Date: 5th March 2024

**Demolition of existing double garage and construction
of detached annexe for elderly relative**
The White House, 62 Market Place, Burnham Market,
Norfolk PE31 8HD
KLWN REF 23/01186/F

Title Proposed Annex

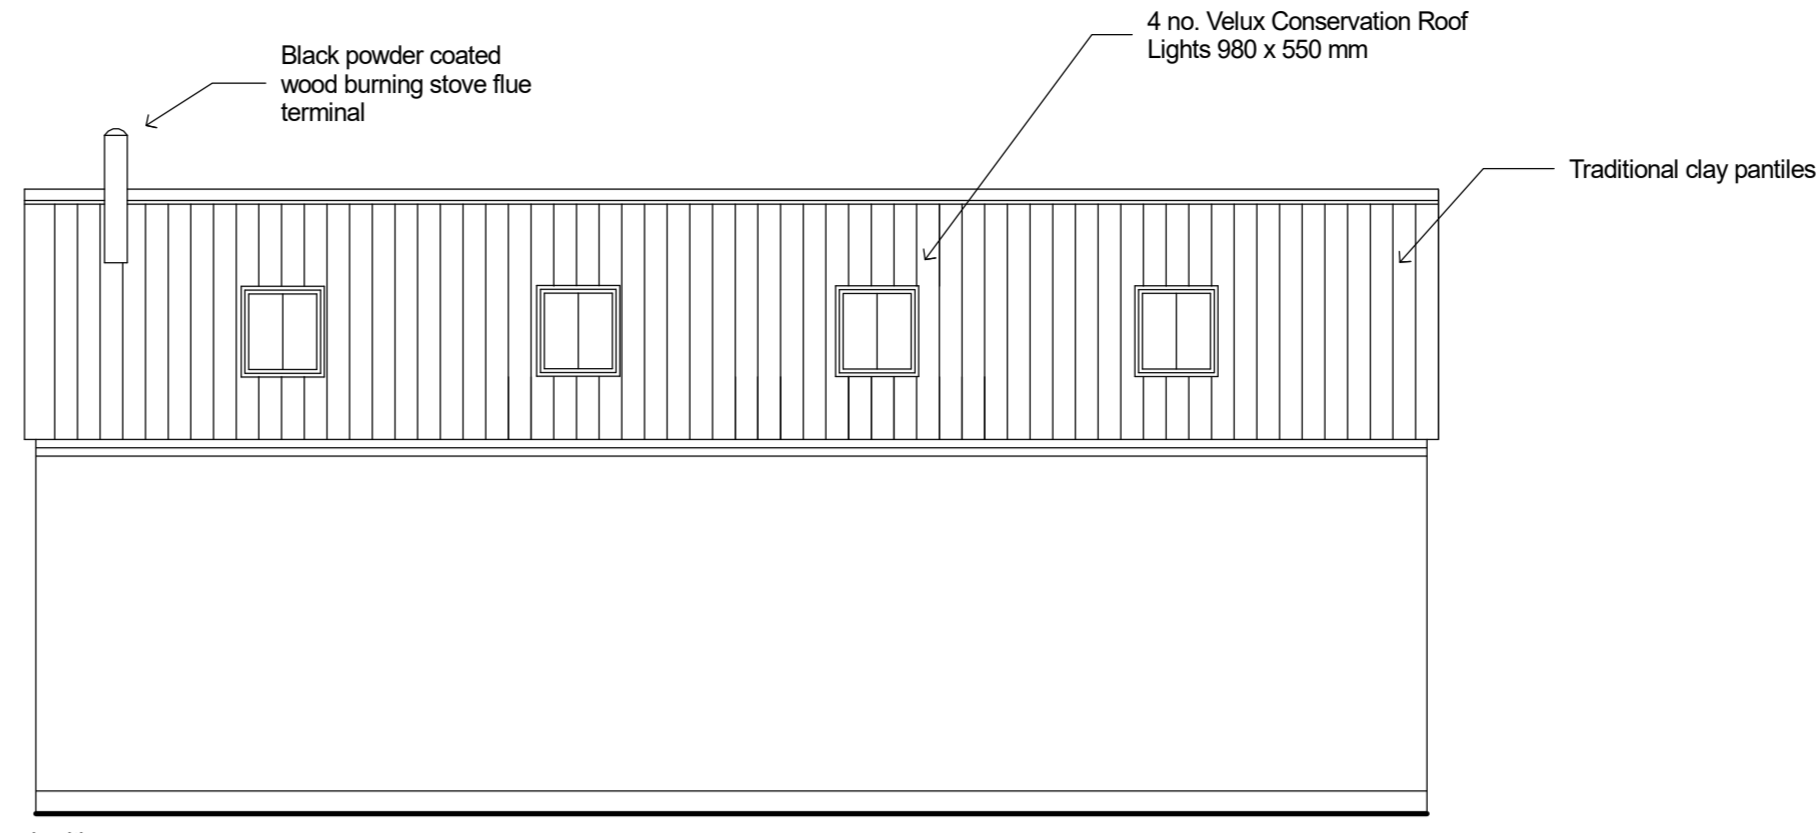
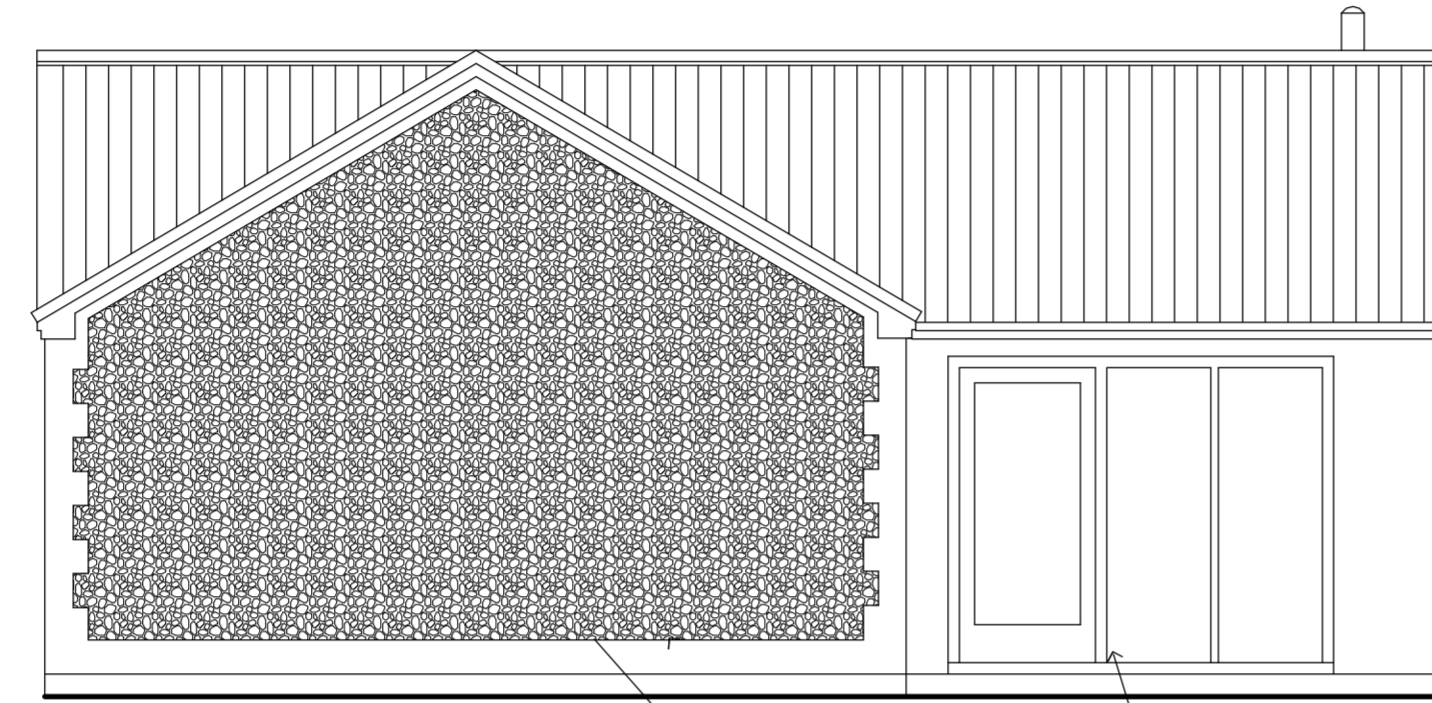
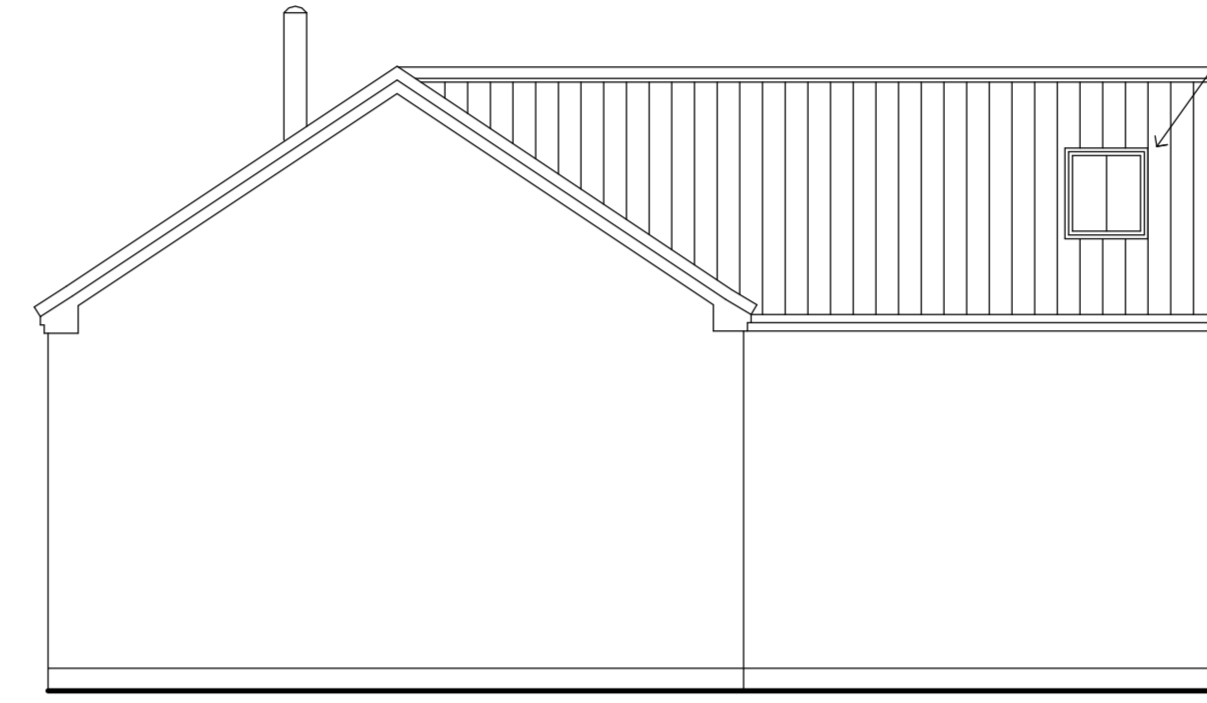
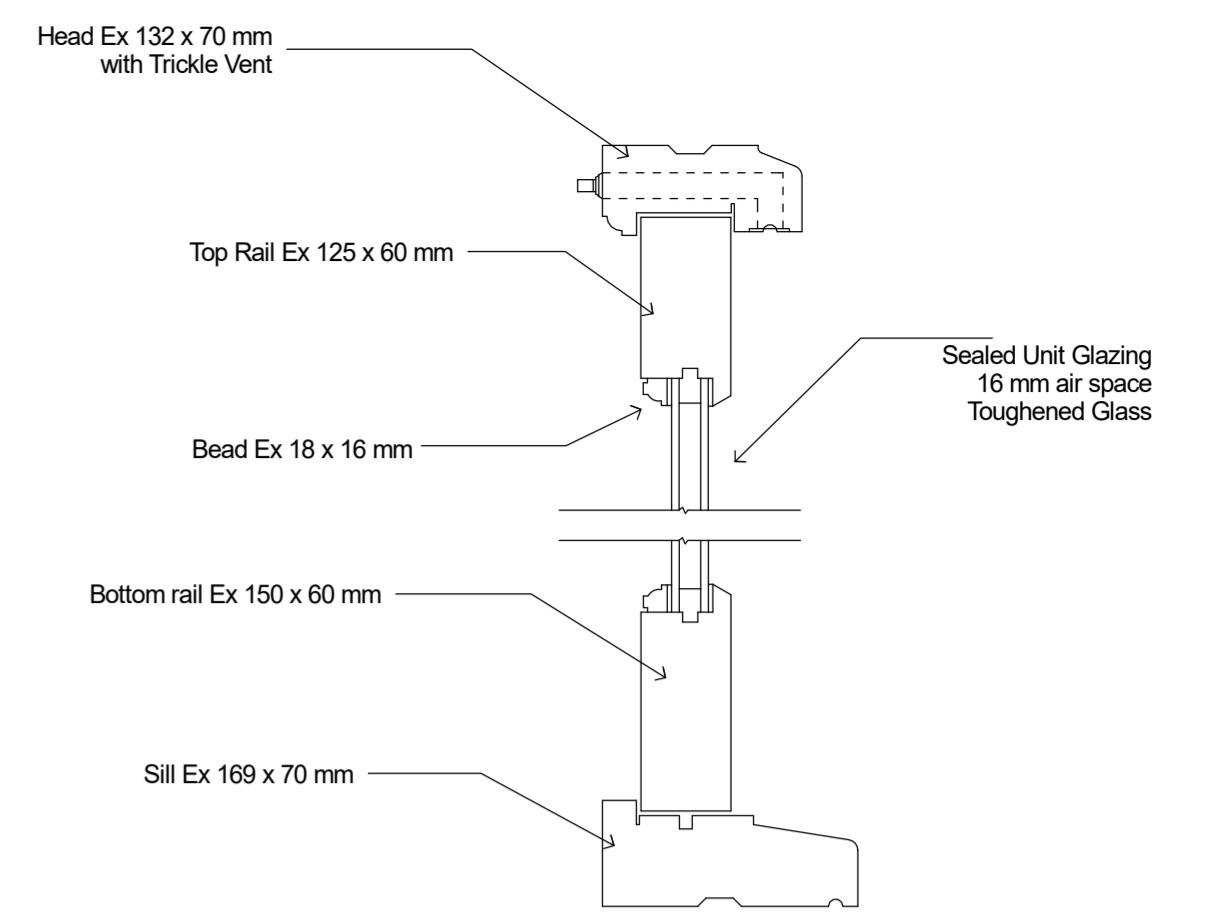
I write regarding the above permission and as we have discussed in respect of the recently submitted 'NMA' submission again confirm that the Building Regs specification work has thrown up the need to see a slight increase in external dimensions to allow for appropriate thermal insulation to be accommodated and internal accessibility requirements to be achieved. It has also presented an opportunity to rationalise some details / specifications, so that for example the annexe could include a traditional side-hung door rather than having to open a bi-fold door to enter / leave.

This proposed changes, although minor in nature and scale have been advised by you not to be considered to fall within the scope of the 'non-material amendment' process, so that even though the small increase to the approved footprint of the annexe would not require any increase in overall height as the roof pitch would be marginally reduced to keep the ridge at the same height as previously approved, it is instead necessary to make this 'S73' submission. I again confirm that the increase in footprint would largely be achieved 'into the curtilage of the host property', mitigating any change to the relationships with neighbouring properties or the amenities of occupants.

Given the changes proposed and inclusion within the submitted drawing ‘**rev E**’ it is proposed to seek the variation of Conditions **02 ‘Approved Plans’** and **06 ‘Joinery Details’** to see the new drawing confirmed as ‘approved’ and the joinery details within as appropriate for the building. The requirement for commencement by 06-12-26 and restriction on occupation would remain, as would the requirement for approval of external finish materials and the construction of a sample panel ahead of ‘above ground’ works.
